PROJECT TITLE: Dialysis Clinic ZONE ATLAS/DRNG. FILE#: J-15 / D046

RE: DIALYSIS CLINIC (1500 Indian School Rd NE) (J-15/D46)
ENGINEERS CERTIFICATION FOR CERTIFICATE OF OCCUPANCY
ENGINEER'S STAMP DATED 9/17/1999 Rev. 10/27/1999
ENGINEER'S CERTIFICATION DATED 3/16/2001

RE: DIALYSIS CLINIC (J15-D46). GRADING AND DRAINAGE PLAN FOR BUILDING PERMIT APPROVAL. ENGINEER'S STAMP DATED SEPTEMBER 17, 1999.

C3.1

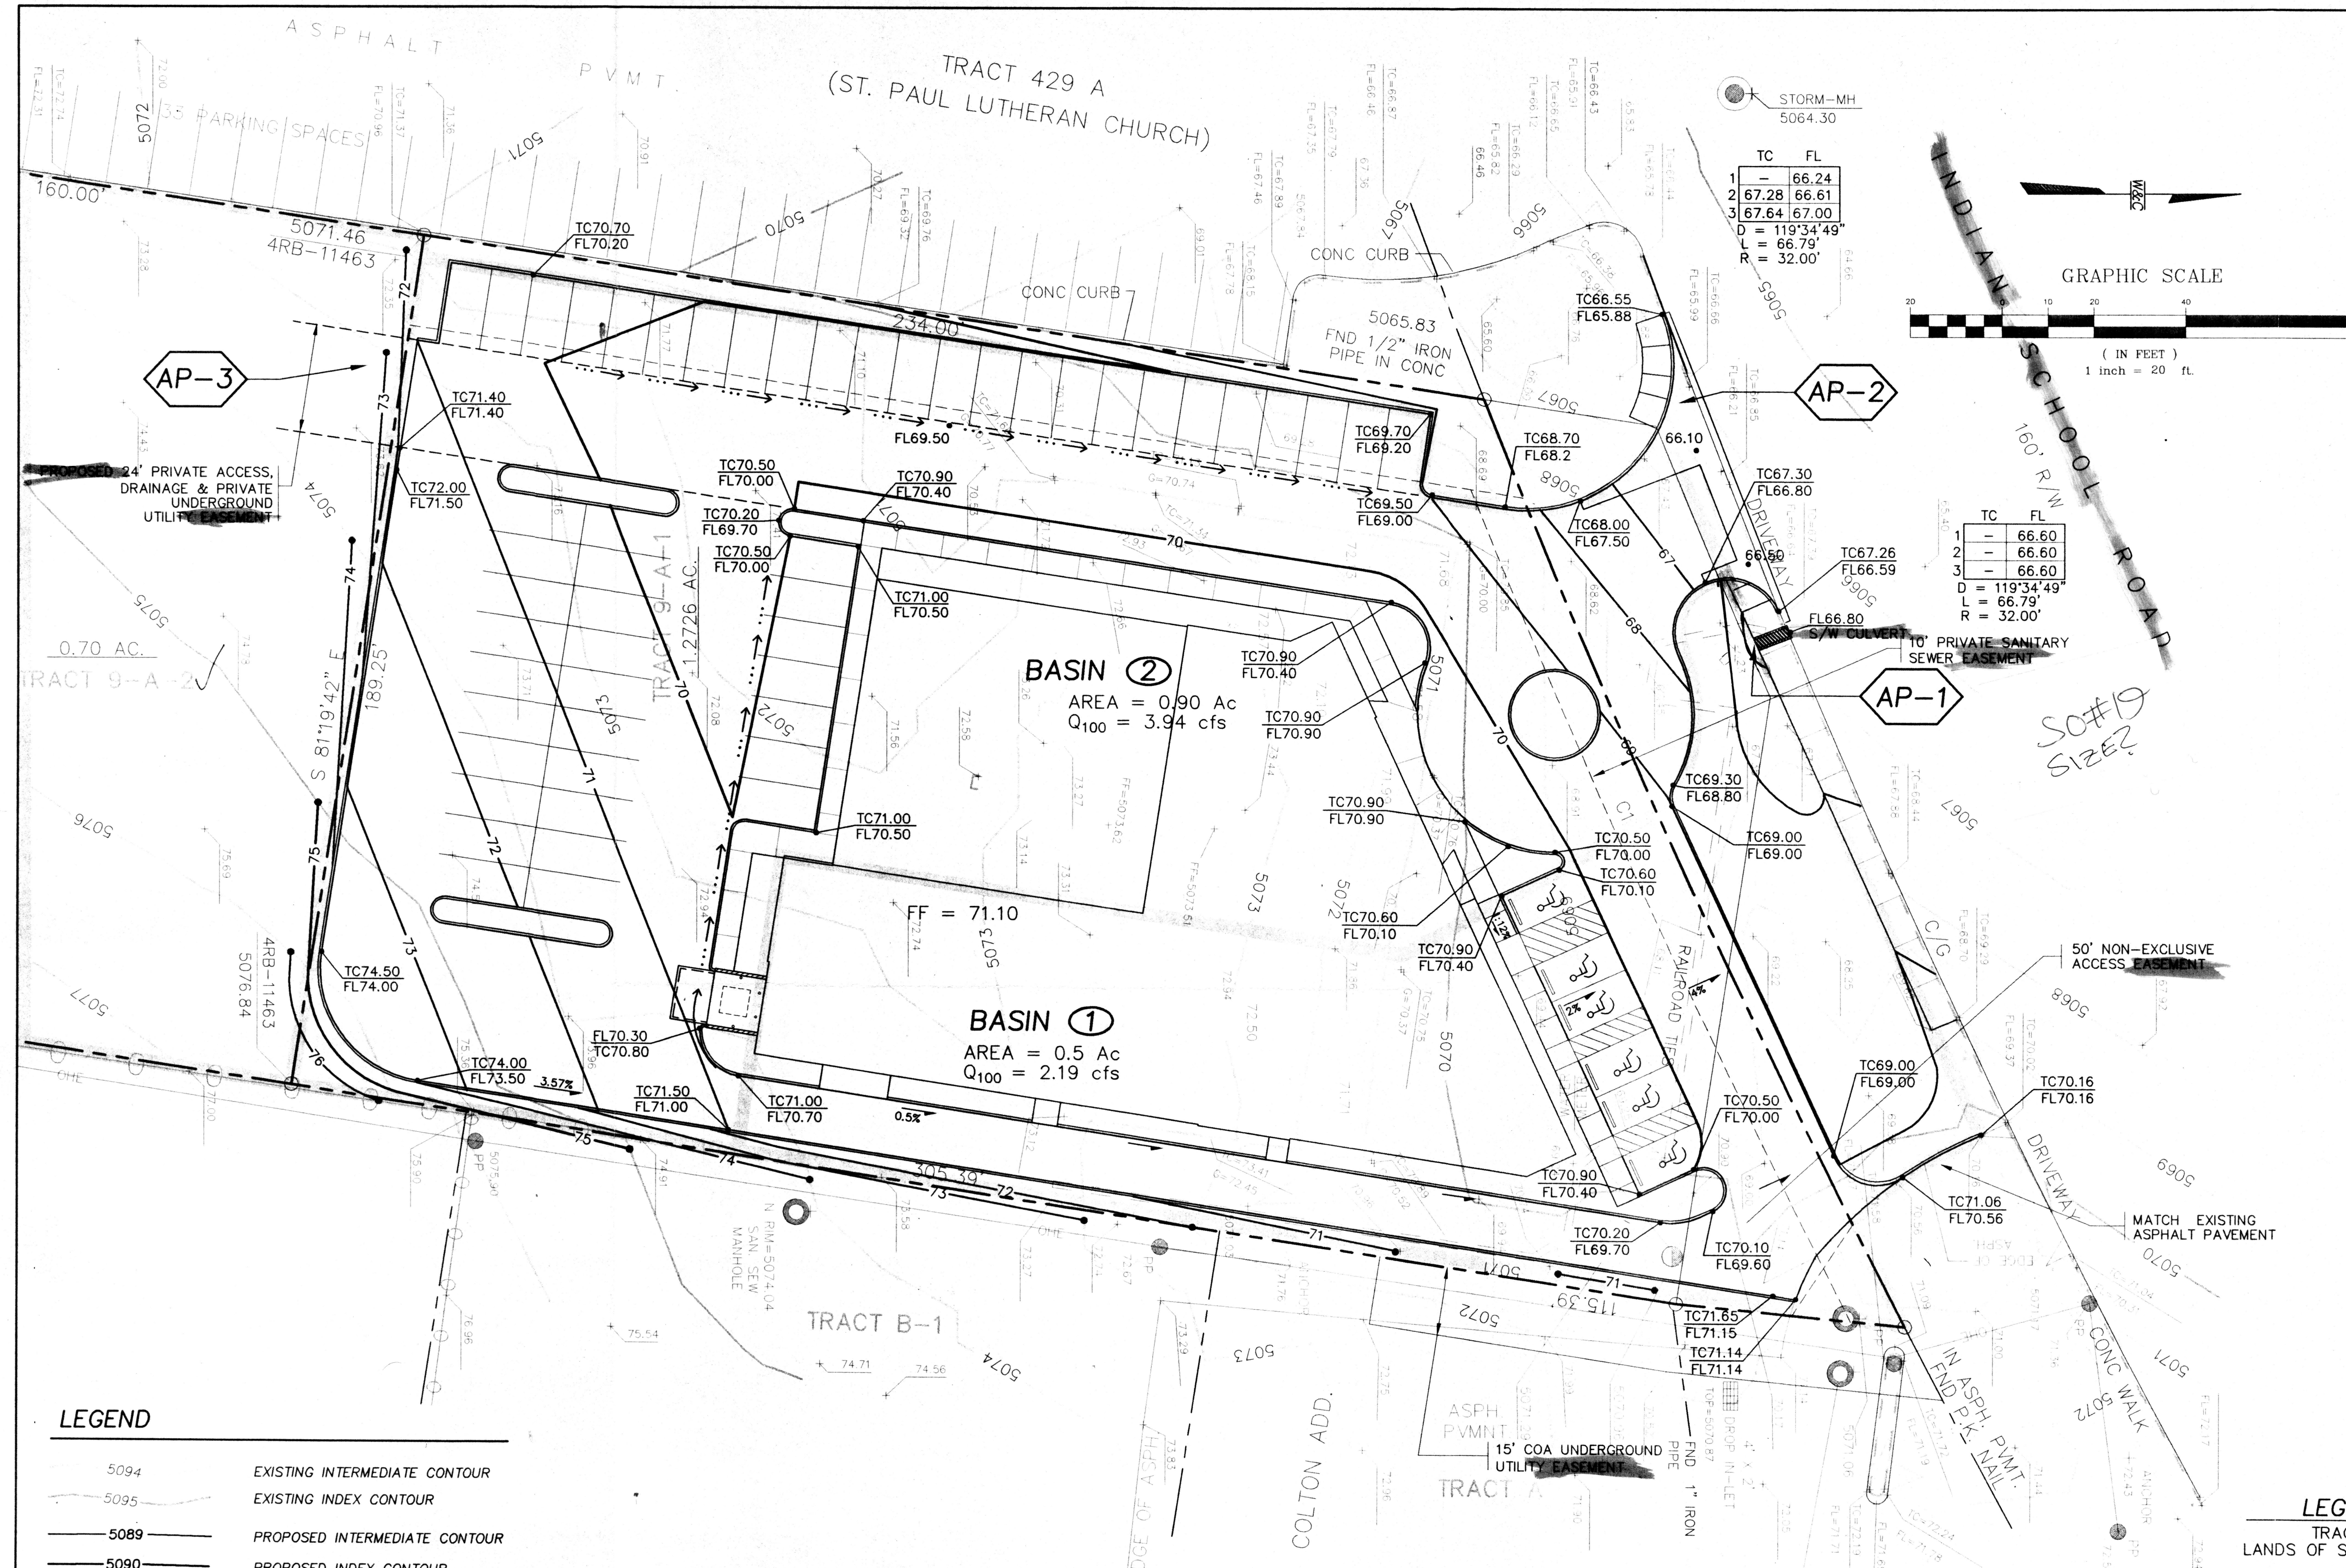
Please add the standard Signature Block and Notes for the SO#19 Permit to this approved plan for its inclusion in the construction sets prior to sign-off by Hydrology. Also furnish a second copy of this approved plan for the SO#19 process.

The proper reference for the FIRM is Panel 332 (Effective date: Sept 20, 1996).

Show and confirm (weir formula) size of sidewalk culvert.
